COMMUNITY SERVICES DEPARTMENT

Subject: Forest Lakes Filing No. 6 Final Plat, Review #2 (SF-20-027)

Forest Lakes Filing No. 6 Final Plat Development Application Review

FOREST LAKES FILING NO. 6
RECEPTION NO. 220714540
COUNTY ZONING: PUD

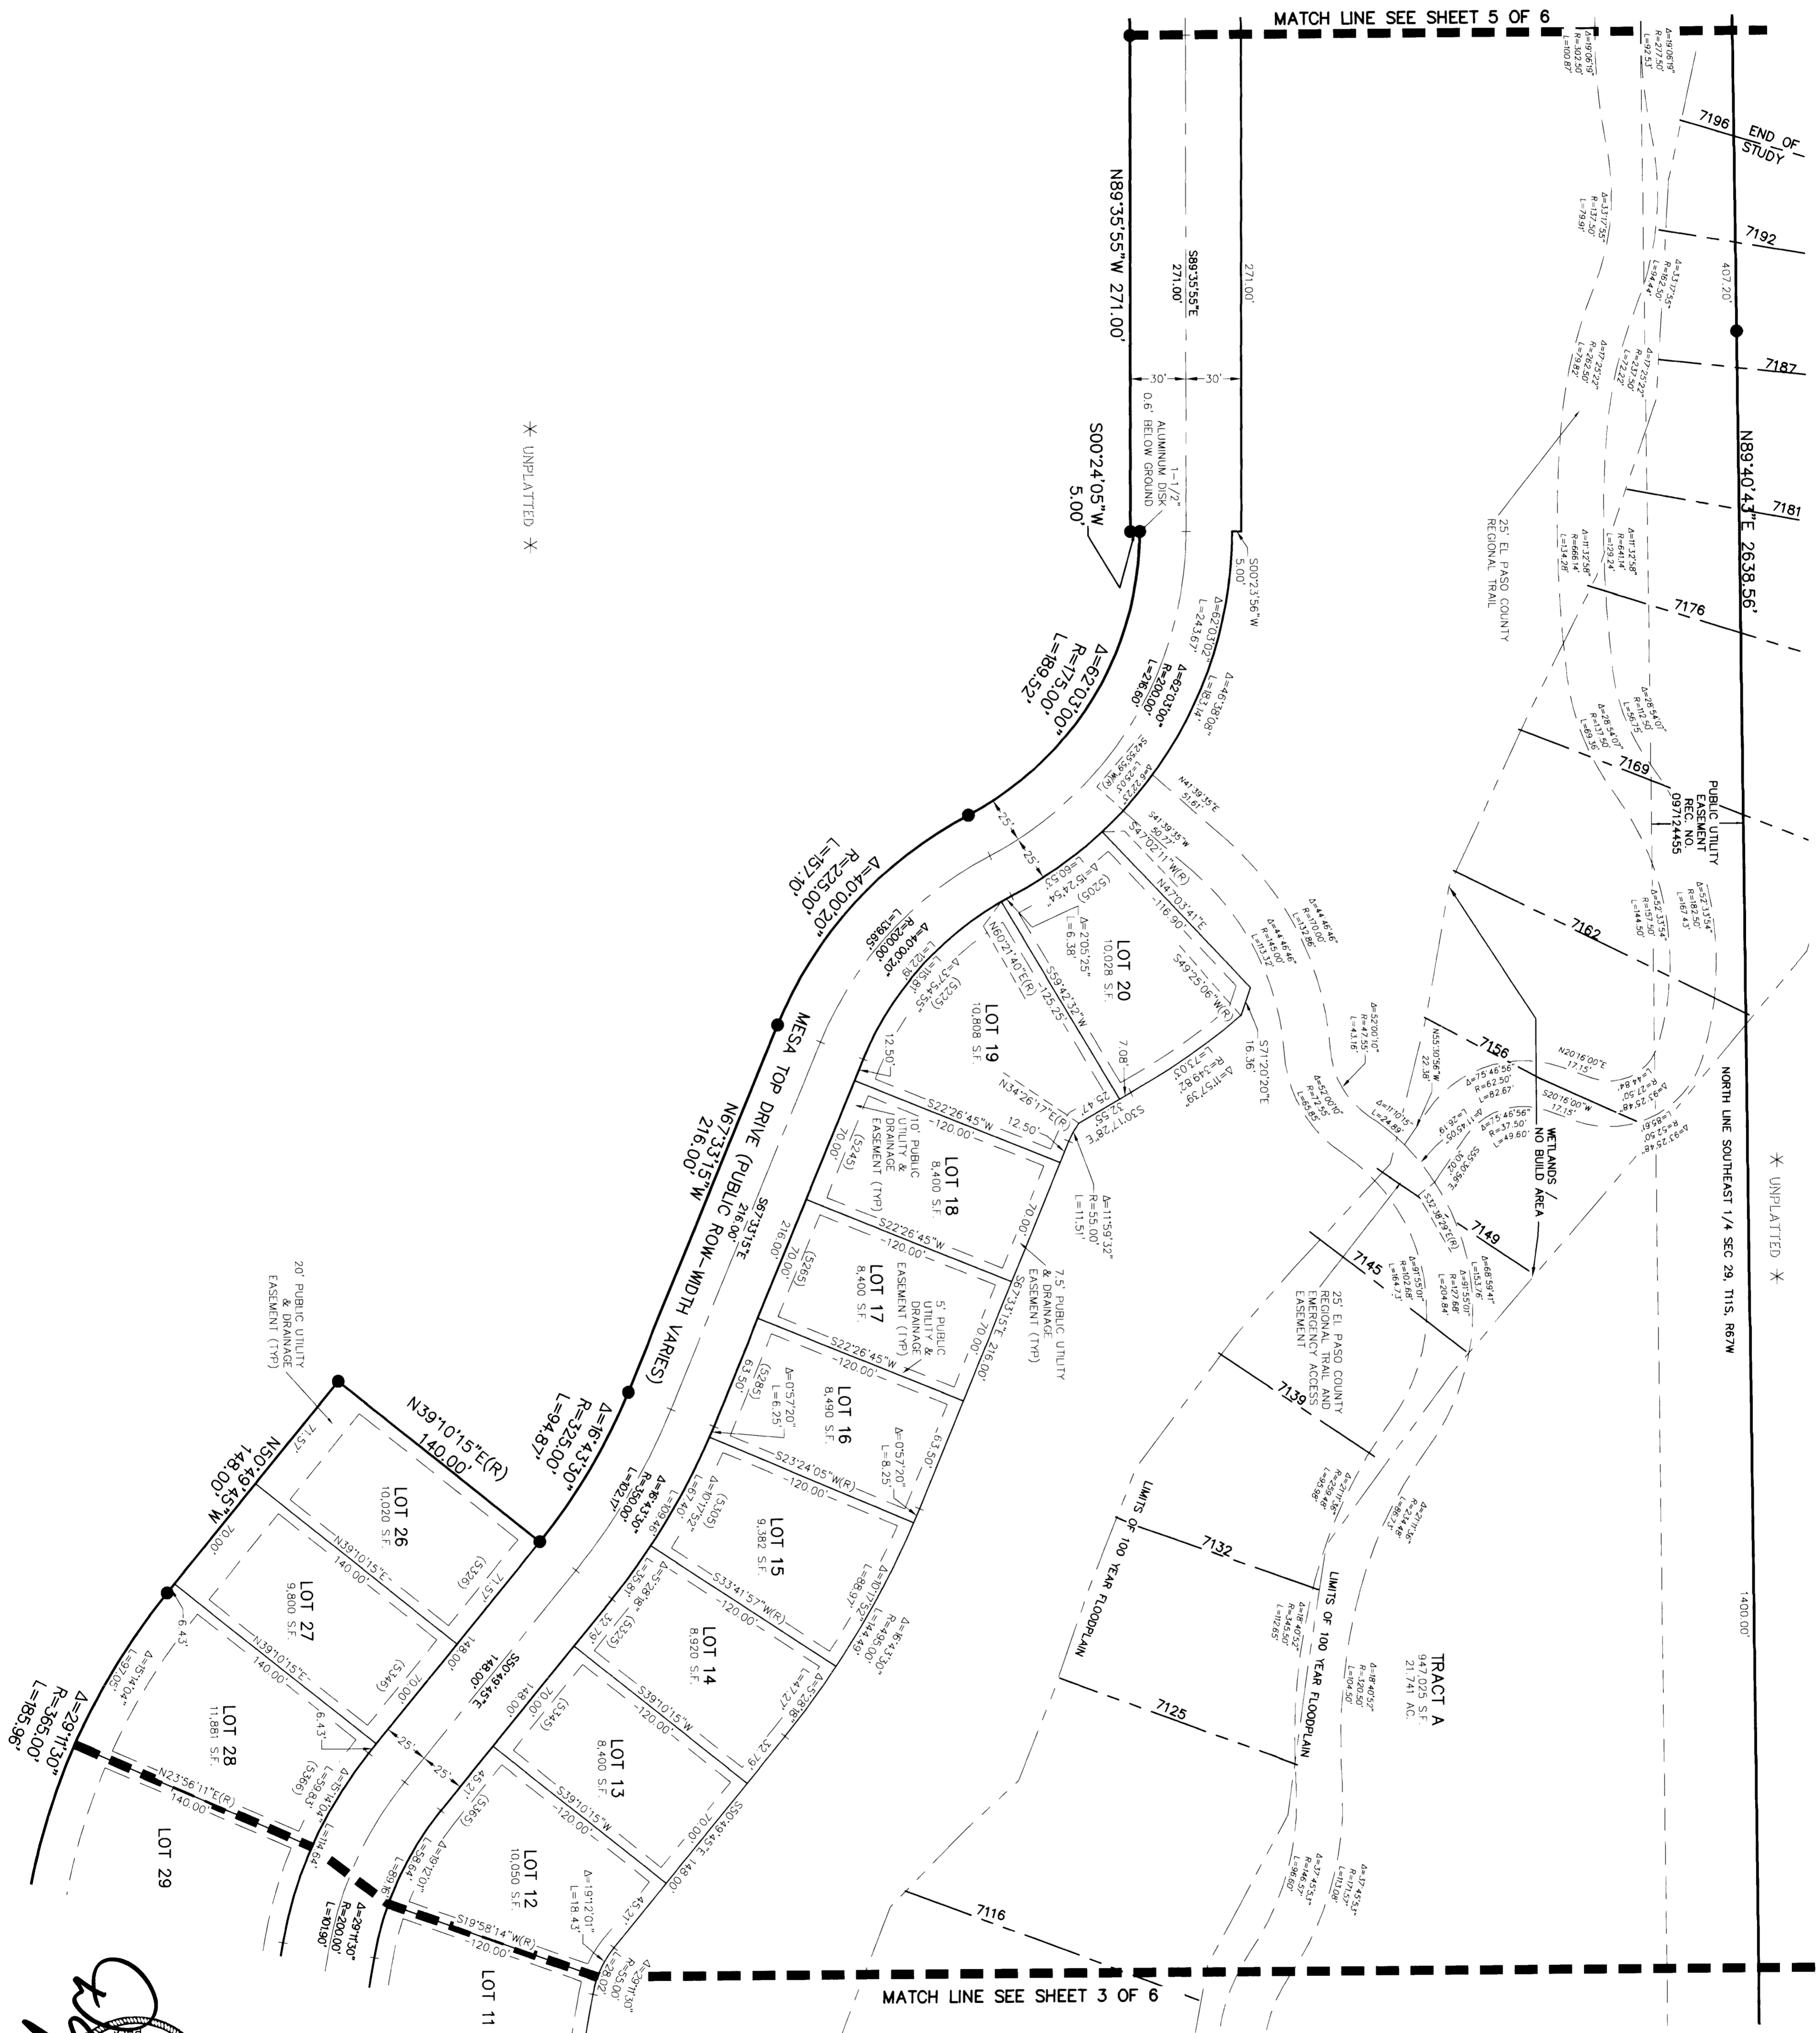
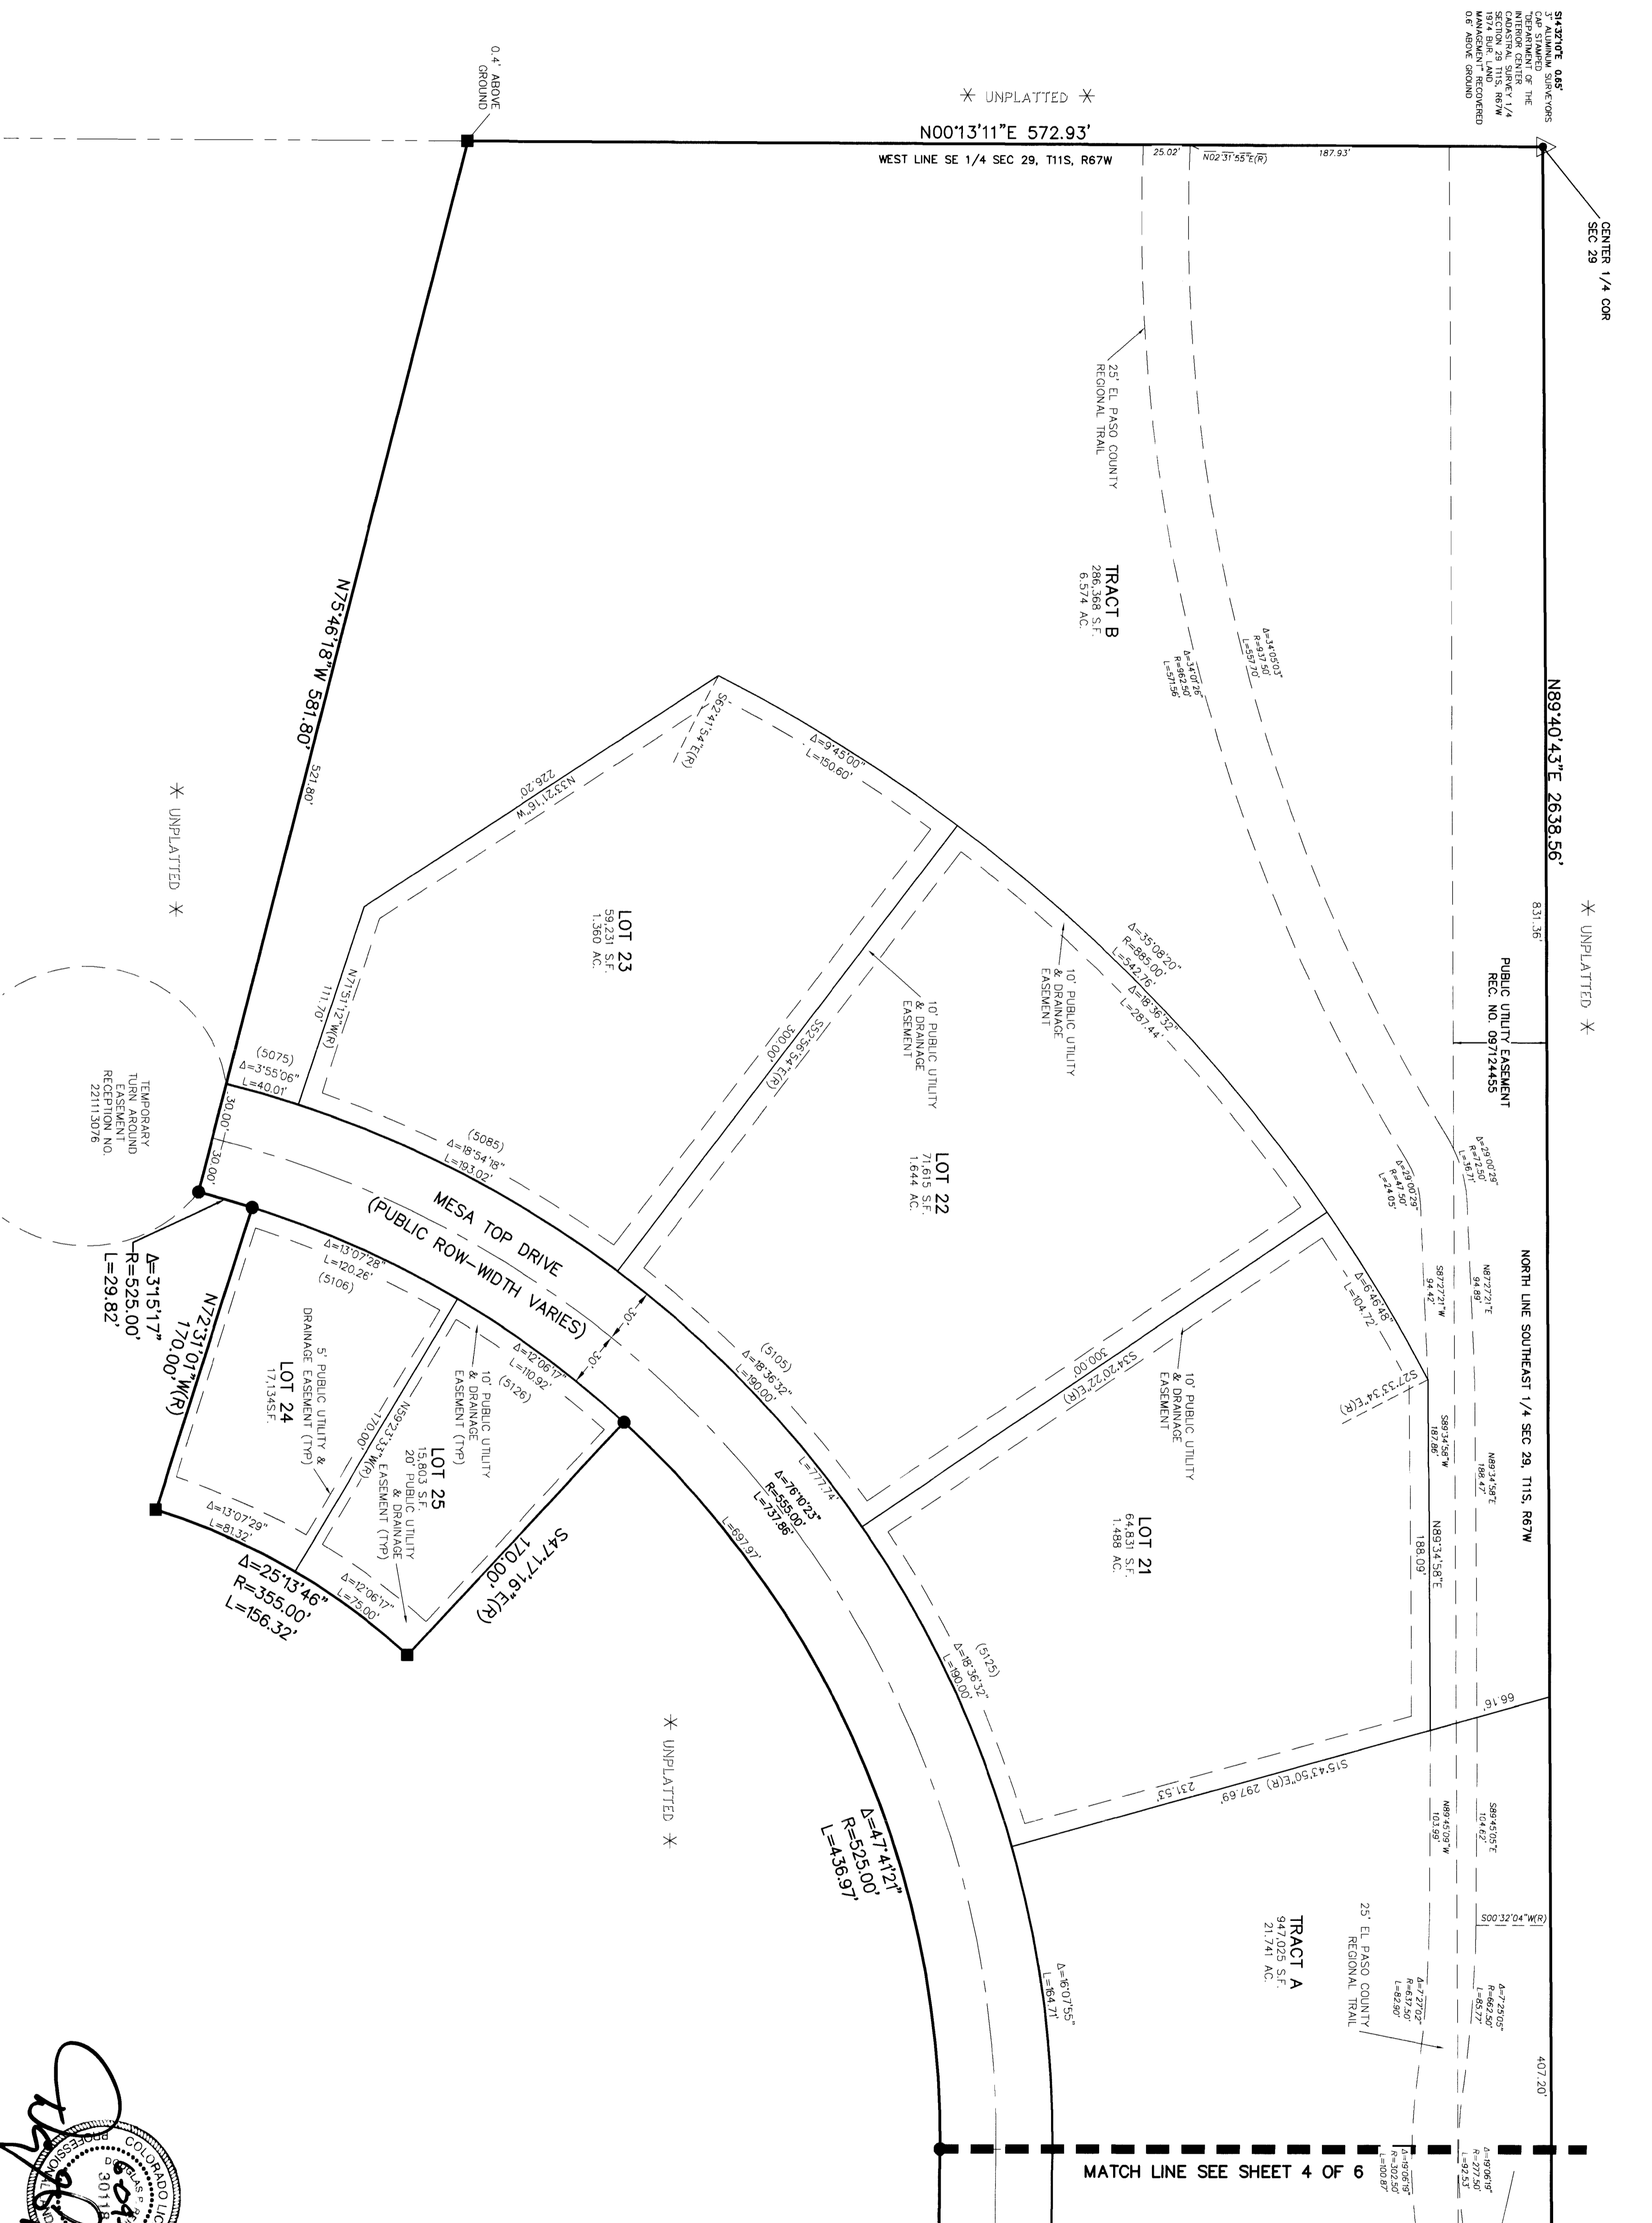
The BoCC-approved Forest Lakes Phase II PUD Preliminary Plan shows in detail the Forest Lakes Secondary Regional Trail, as well as the internal trail network and emergency access road. However, the Forest Lakes Filing No. 6 Final Plat does not show the 25-foot trail easement through the project site, and

the Final Plat notes do not reference the dedication of the trail easement to El Paso County. As such, staff recommends that the applicant include the easement alignment in the Final Plat drawings and include language in the Final Plat General Notes that designates and provides to El Paso County a 25-foot trail easement through Forest Lakes Filing No. 6, within Tracts A and B, that allows for public access of the Forest Lakes Secondary Regional Trail, and dedicate the aforementioned easement to El Paso County prior to the recording of the Final Plat.

The Park Advisory Board recommends that the Planning Commission and the Board of County Commissioners include the following conditions when considering and/or approving the Forest Lakes Filing No. 6 Final Plat: (1) designate and provide to El Paso County a 25-foot trail easement through Forest Lakes Filing No. 6 Final Plat, within Tracts A and B, that allows for public access of the Forest Lakes Secondary Regional Trail, and dedicate the easement to El Paso County within the Final Plat General Notes prior to the recording of the Final Plat; (2) regional park fees are not required pursuant to the existing Forest Lakes Phase I PUD Preliminary Plan and Filing No. 1 Final Plat recommended and endorsed motions; (3) the section of the Forest Lakes Secondary Regional Trail located within Filing No. 6 shall be constructed within two years of the recording of the Final Plat; (4) trail plans shall be submitted to and approved by County Parks prior to construction; (5) the trail shall be constructed to Tier 1 standards for a regional trail; (6) the trail shall be maintained by the Forest Lakes Metropolitan District when contained within developer-owned tracts, while El Paso County agrees to maintain the Regional Trail when contained within dedicated roadway rights-of-way; (7) require fees in lieu of land dedication for urban park purposes in the amount of \$20,060. A Park Lands Agreement may be an acceptable alternative to urban park fees, provided the agreement is approved by the County and executed prior to recording the Final Plat."
